**Bersted
Parish Council**

1st February 2012

Re: BE/151/11 Shripney Caravan Park

SHRIPNEY GARDEN CARAVAN PARK, SHRIPNEY LANE, SHRIPNEY
Proposals 01 B
Nov 2011

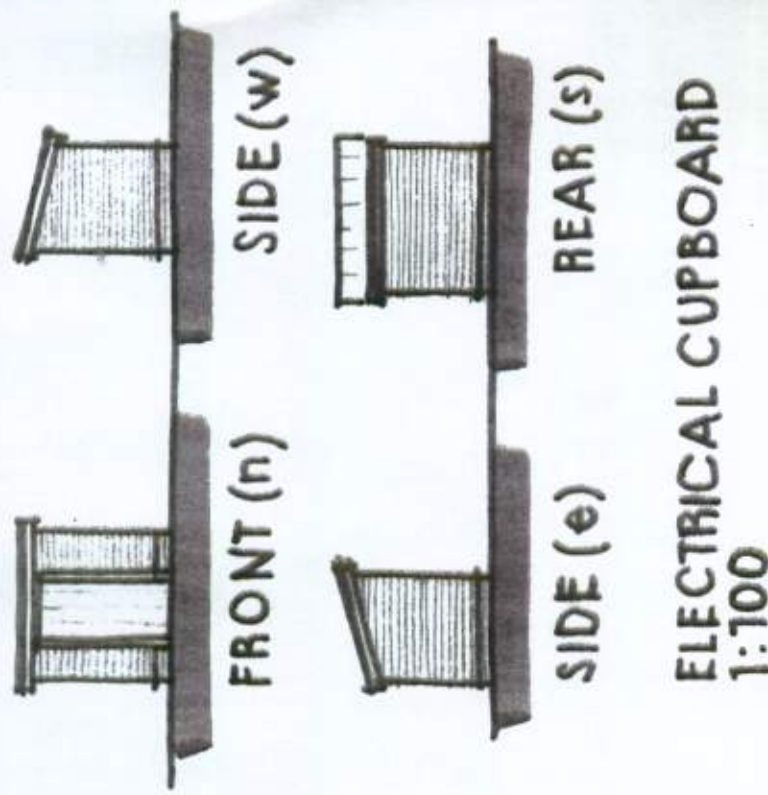
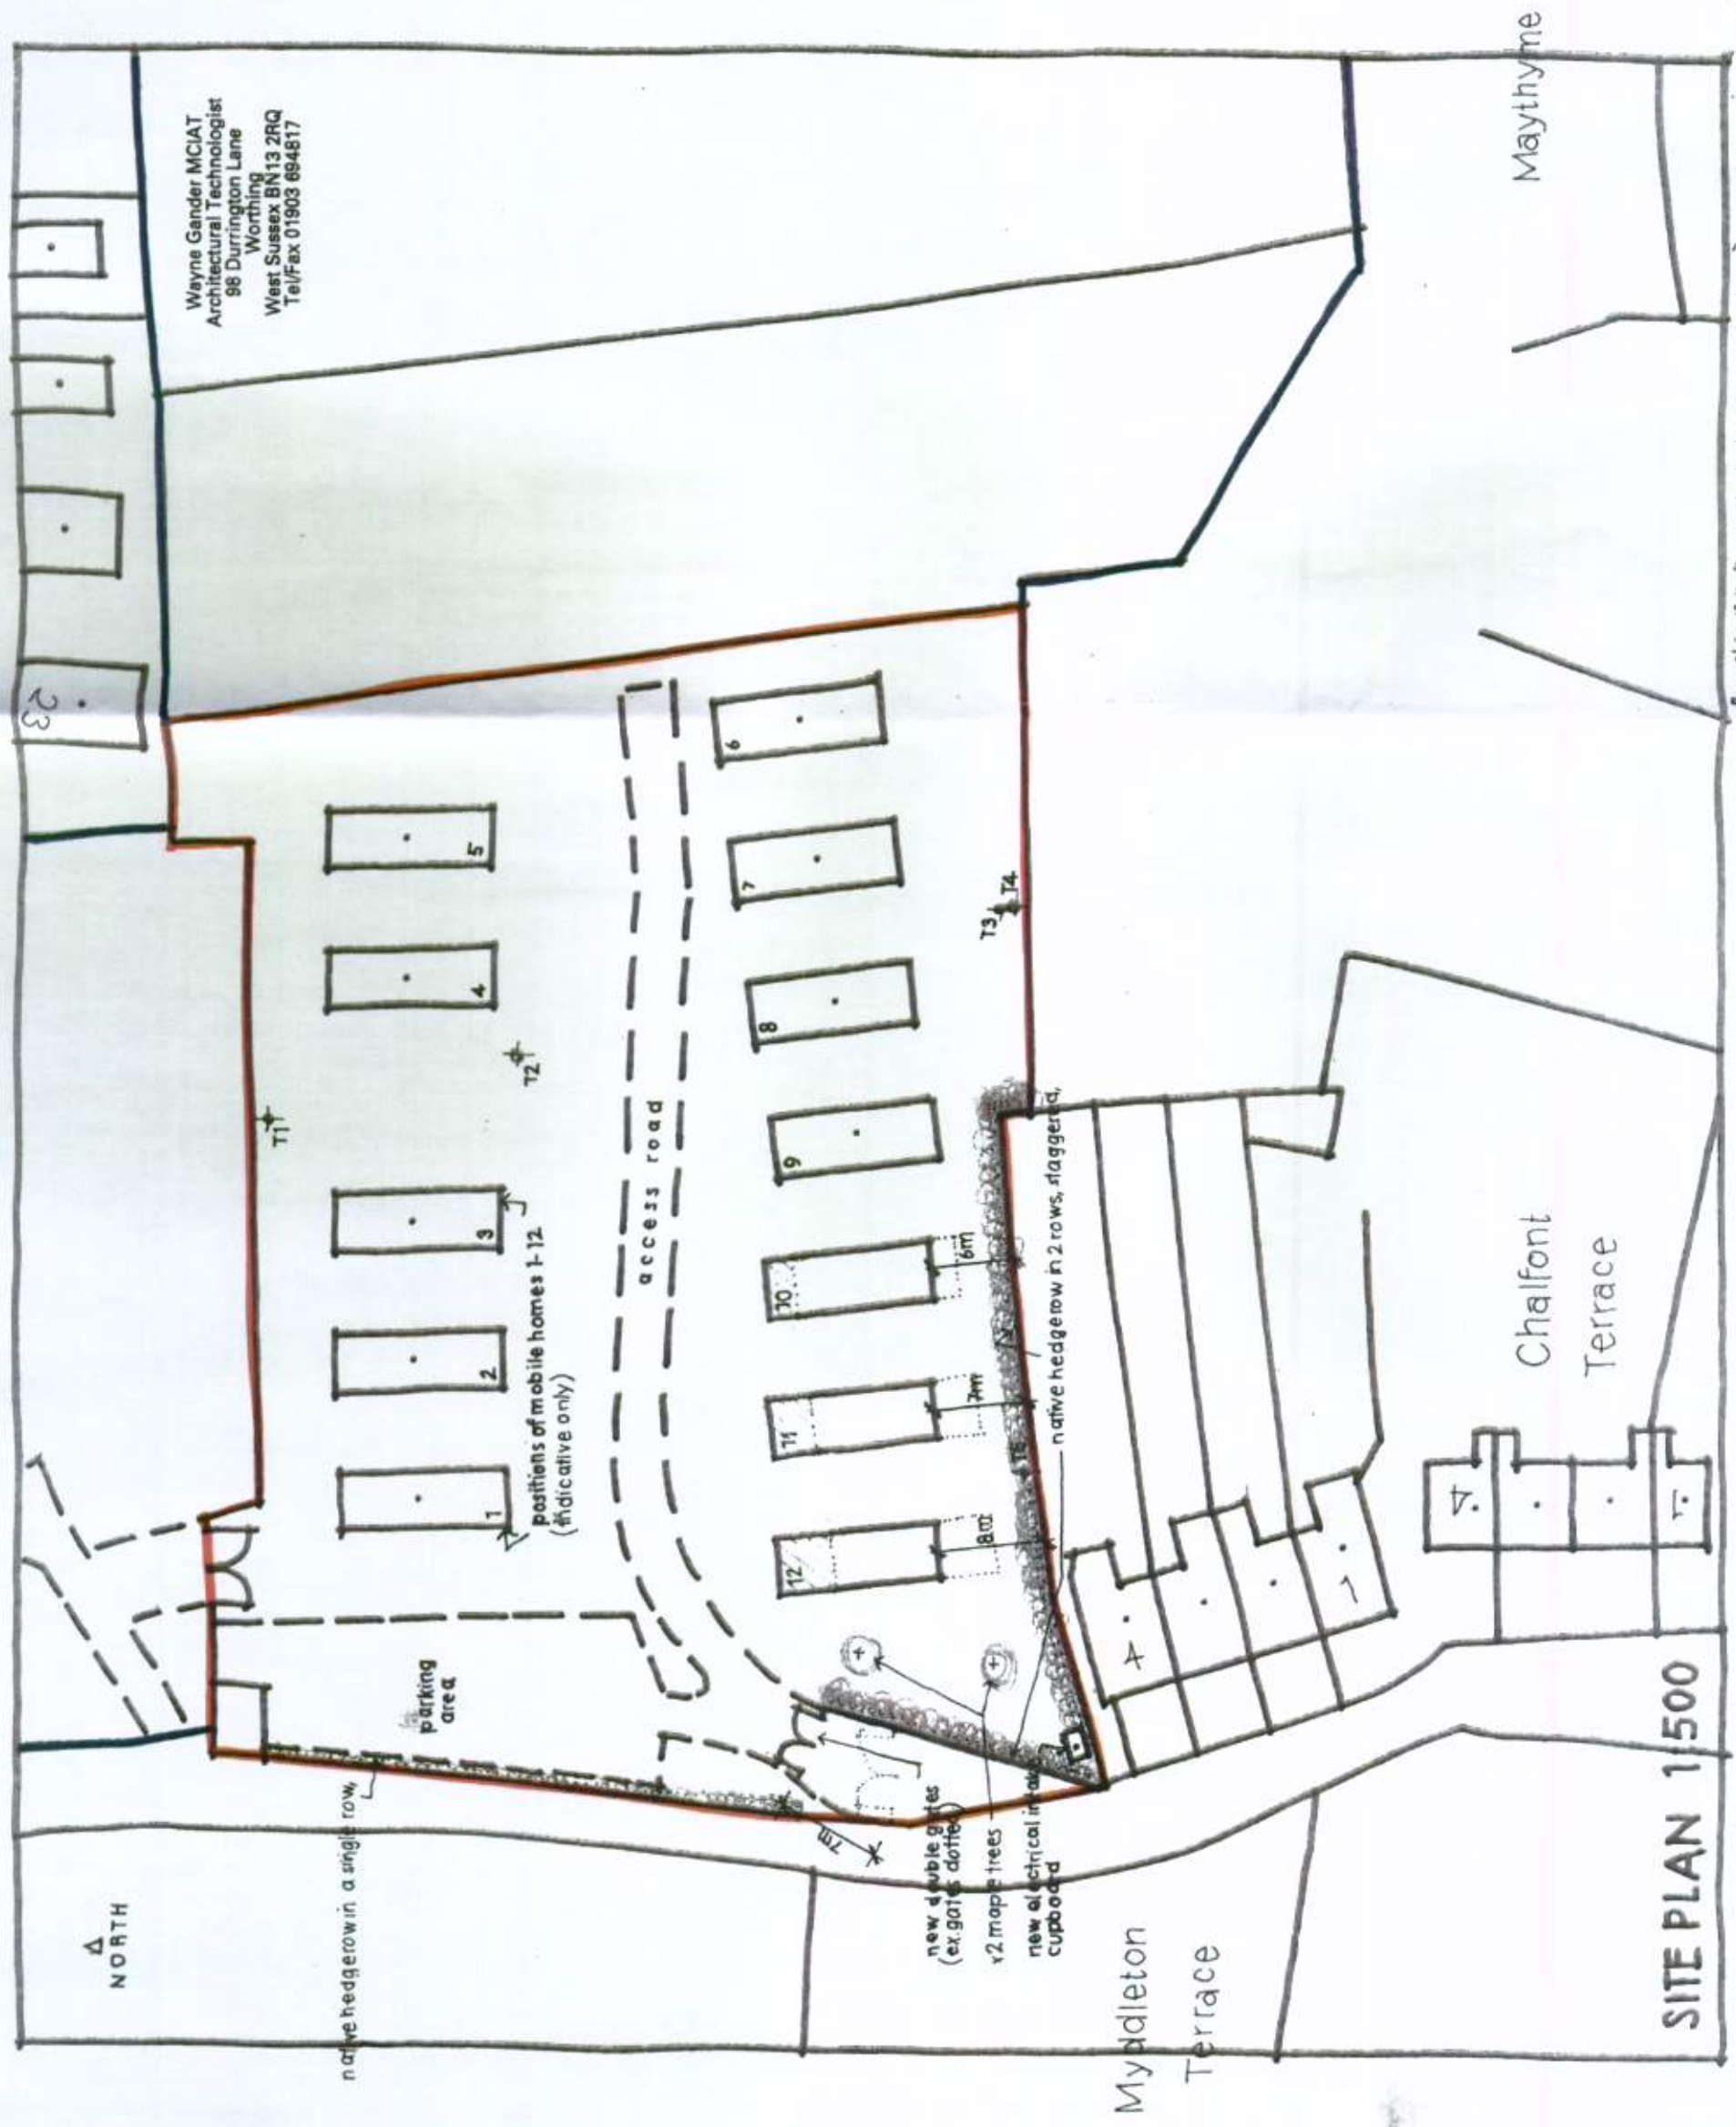
As clerk, and on behalf of the Planning Committee, I would like to inform you that the council does not have an objection to the above planning application modification. Members visited the caravan park on Monday 30th January. The caravans nearest to the residents will now be moved further away, partial landscaping has taken place and the gate moved in order to accommodate vehicles off the access road. Members agreed that these measures would mitigate the position of the caravans in relation to the existing residents

- Privacy. Mrs Jolley, the resident most directly affected, does not think the landscaping will be a good enough barrier. The landscaping is very immature at the moment and quite sparse, it is hoped that more dense, native flora could be added to screen and shelter.

- the new entrance should be for caravans only. In order to minimise engine noise and pollution all other vehicular access should be from the other entrance further away from the existing housing.

I would appreciate it if you can confirm that the existing landscaping will be increased to include native flora which does create a barrier and further thought is given to the possibility of vehicular restriction at the first entrance.
